Phone: 0300 123 6780  
Email: developeras@lancashire.gov.uk  
Your ref: 03.2024.0277  
Our ref: 03.2024.0277  
Date: 24.06.2024

**Planning application no.: 3.24.277**

**Proposal: Proposed porch to side, single garage to side, dormer to rear and single storey extension to rear**

JM-0299
PROPOSED
SITE PLAN

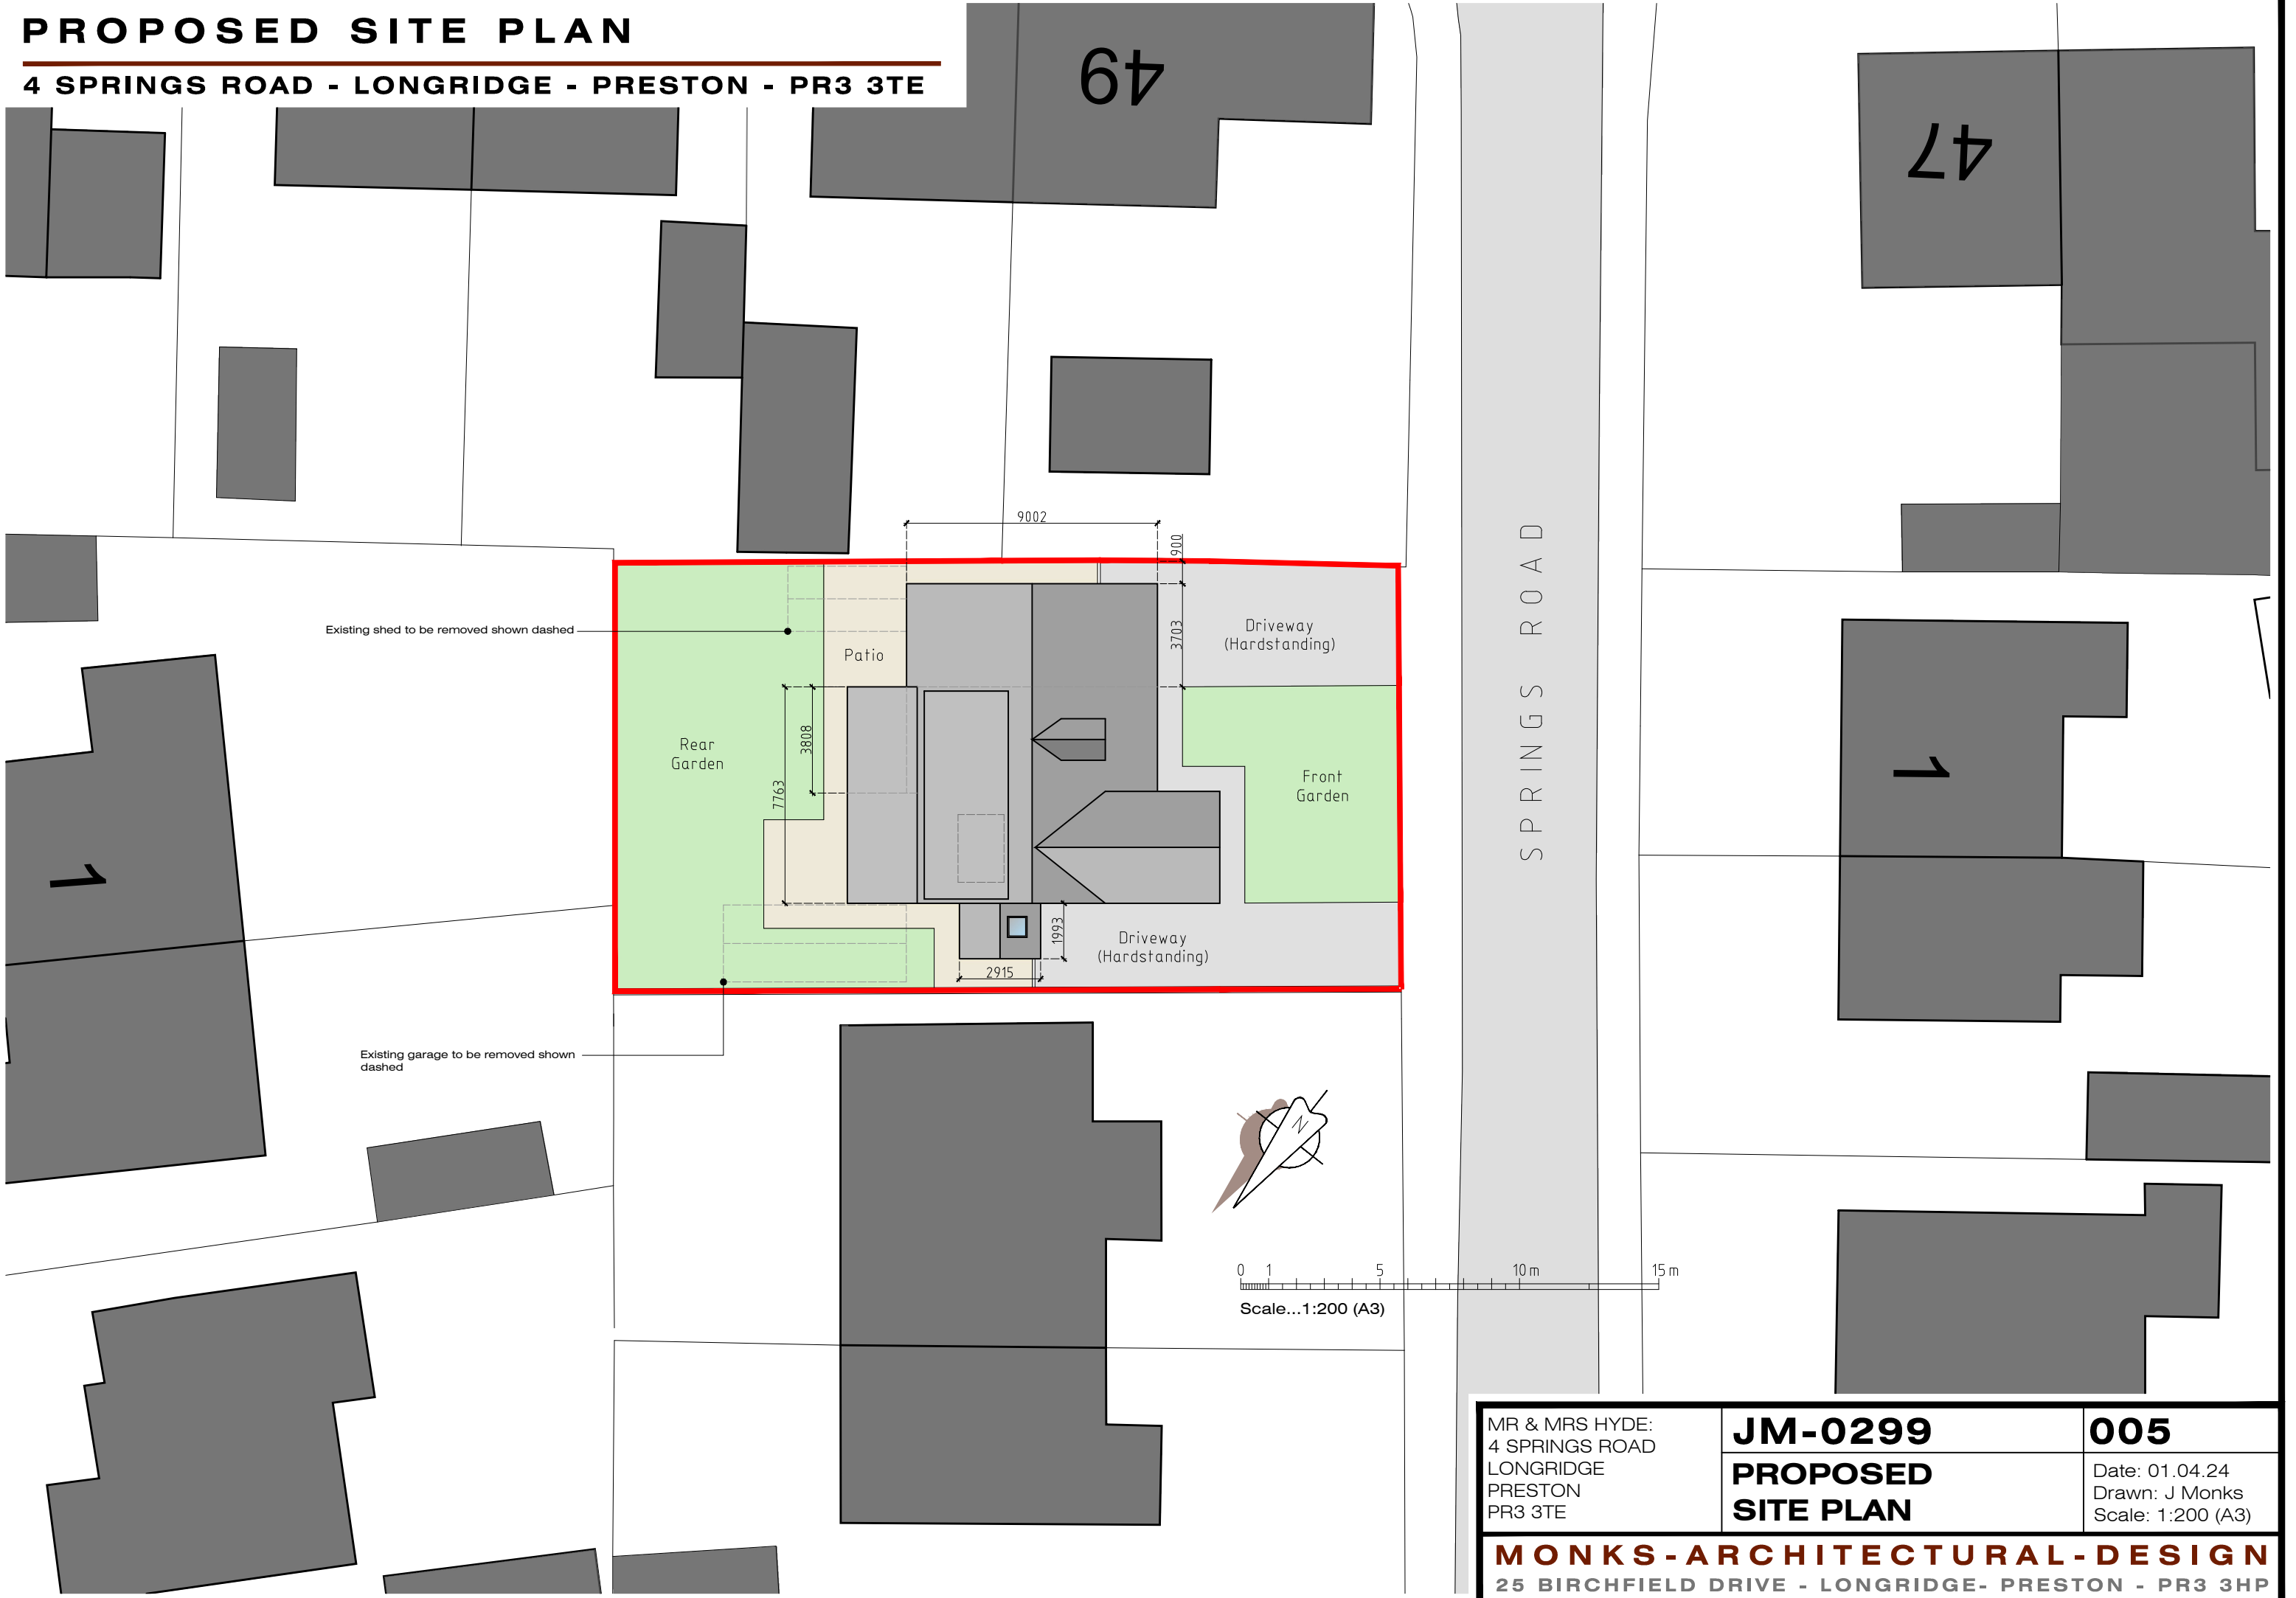
- The garage hereby approved shall be kept freely available for the parking of cars and shall not be converted for any other use without the submission and grant of a planning permission for that purpose by the local planning authority. Reason: To allow for the effective use of the parking areas.
- The parking areas must be constructed of a bound porous material in order to ensure that satisfactory parking is provided before the proposal hereby permitted becomes operative.
